**Item No.**                      **Report of the Head of Development Management and Building Control**

**Address:**                      64 LANGLEY CRESCENT HARLINGTON

**Development:**                Erection of single storey part side to rear extension

**LBH Ref Nos:**                6048/APP/2025/3014

PROPOSED REAR ELEVATION

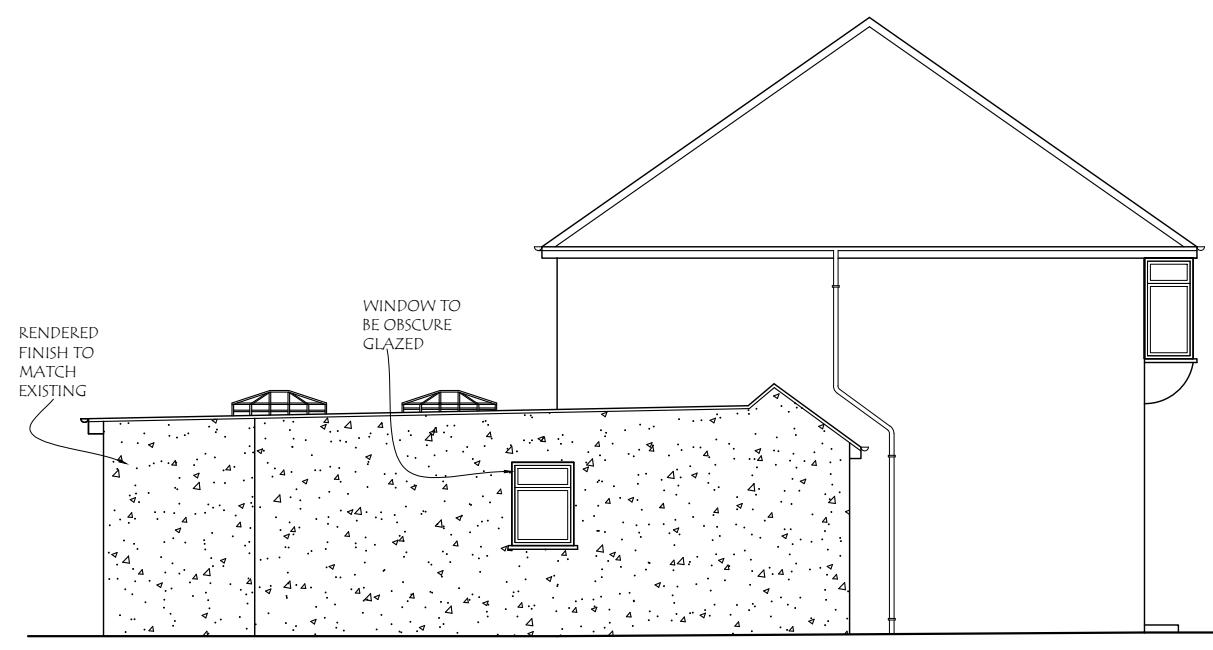
The proposed rear extension would project 4m to the rear, stepping out to 6m in depth at a distance of 5.3m from the boundary with Number 62 Langley Crescent. The extension will wrap around the side elevation, retaining a gap of 1m to the side boundary. The side extension is proposed to be set back from the front wall at a width of 1.47m, widening to meet the rear extension. The extension will be finished with a flat roof with a small area of false pitch to the front of the side extension. The extensions will accommodate a ground floor en-suite bedroom, shower room and extension to the kitchen/dining area.

Whilst officers acknowledge that the proposed extension exceeds the maximum depth required by Policy DMHD1, it will appear subordinate to the host dwelling. Being single storey and finished with a flat roof, retaining a gap to the side boundary which is defined by a 1.8m high concrete panel wall, the proposed extension is not considered to result in sufficient visual harm to the area to justify a refusal of planning permission. Sufficient garden space would be retained to the rear which would ensure that the extension would not appear cramped within its setting.

DRAWING TITLE: PROPOSED BLOCK PLAN
DRG. NO. - 05

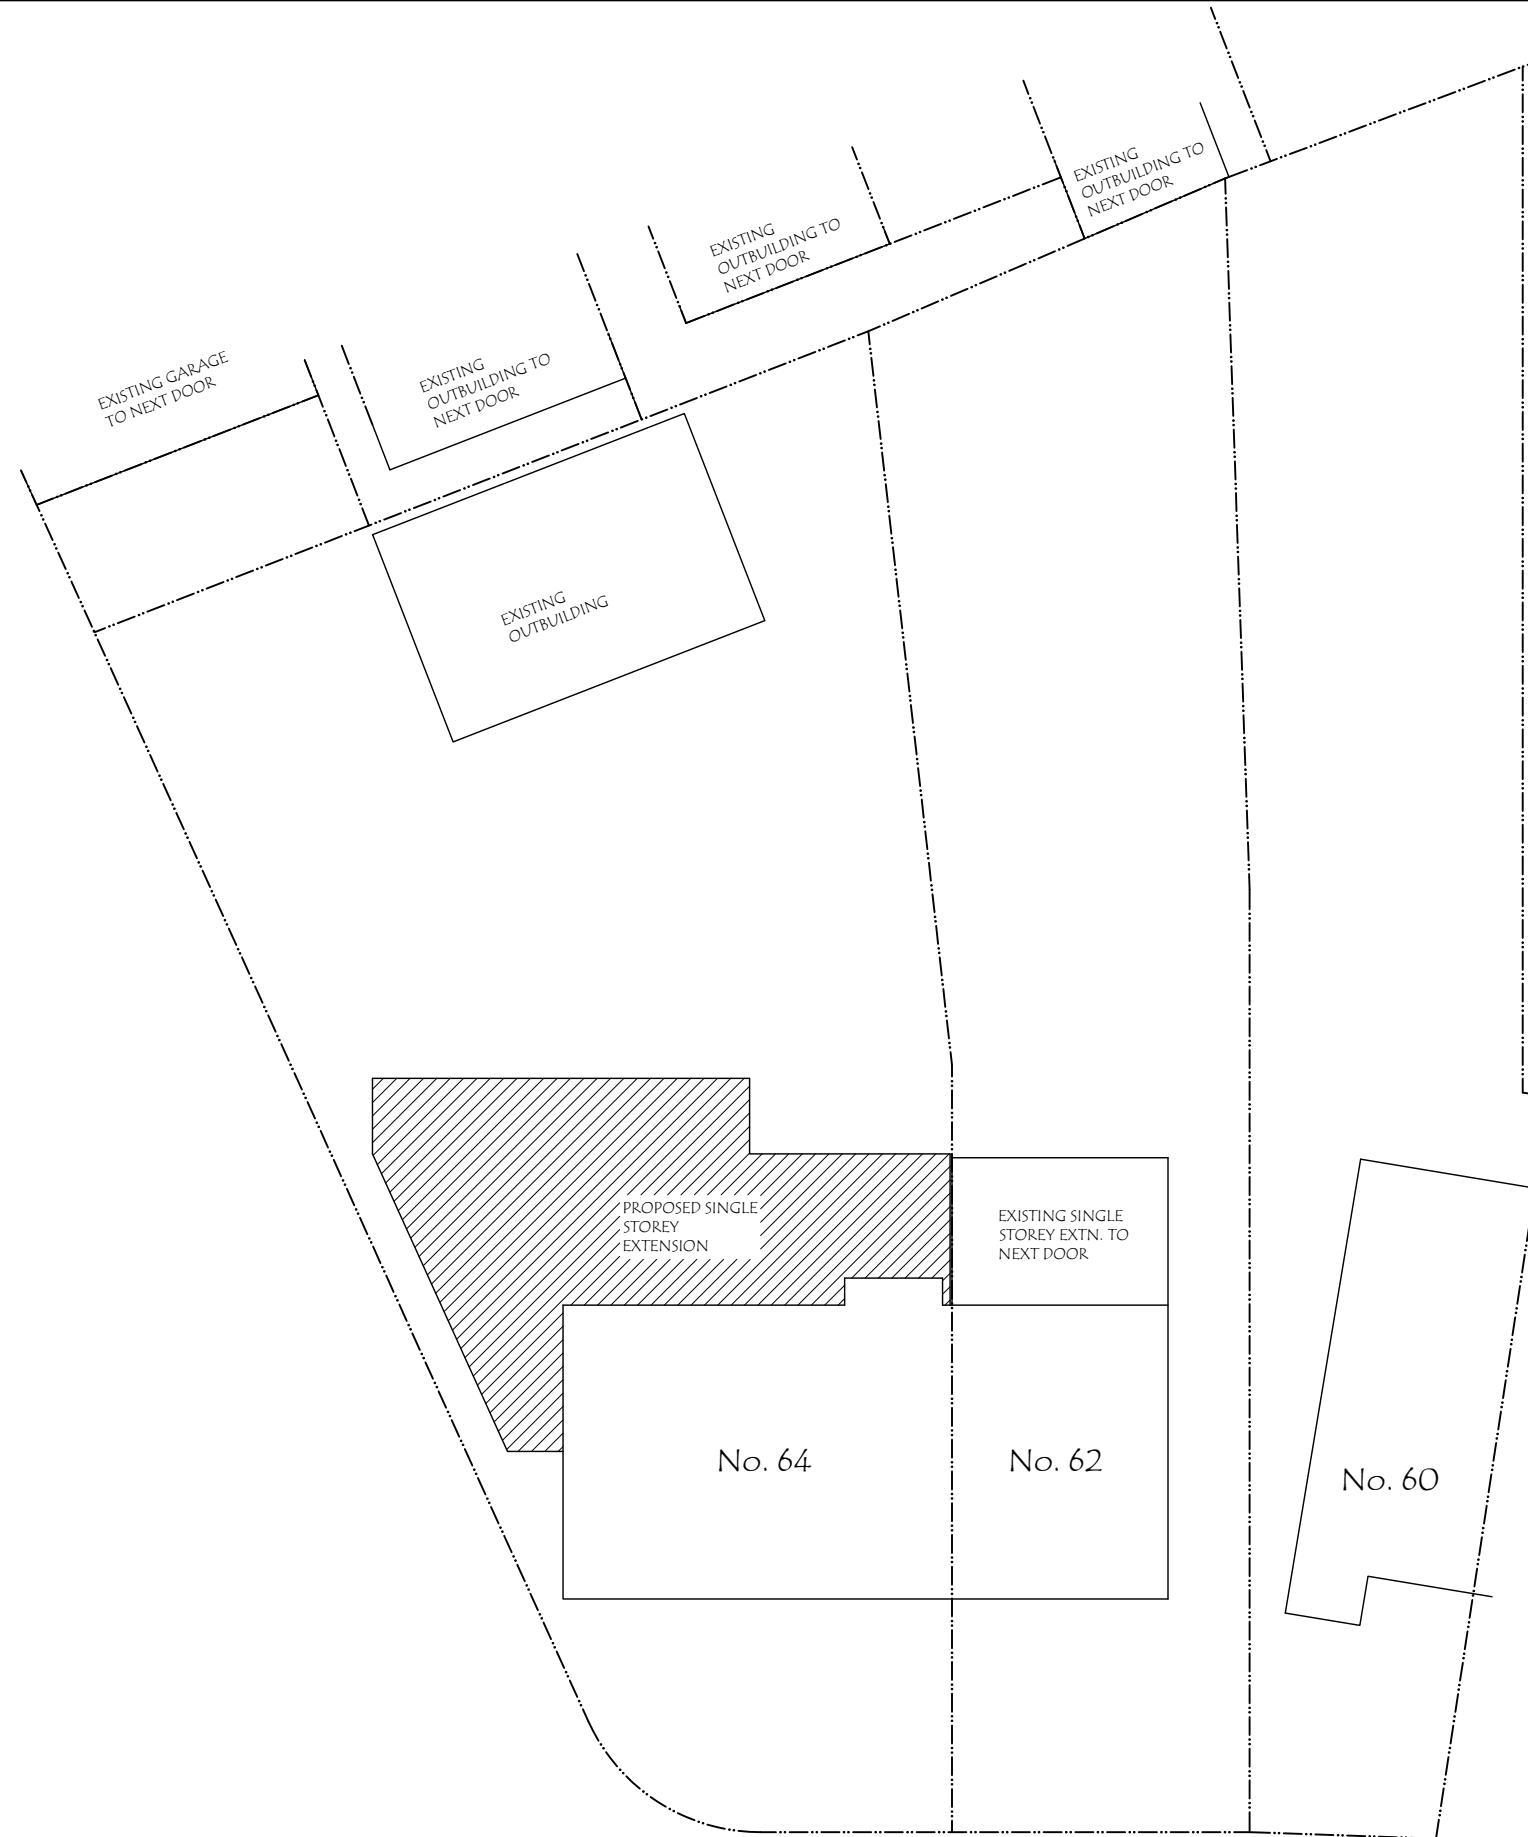
property. The 6m deep element is set 5.3m off this boundary and in light of the separation and modest projection of 2m beyond the rear wall of Number 62 Langley Crescent, officers are satisfied that the proposal would not result in unacceptable loss of light and outlook to the occupants of this property.

Following the redevelopment, the rear garden would retain 105 sq. m. of private amenity space.
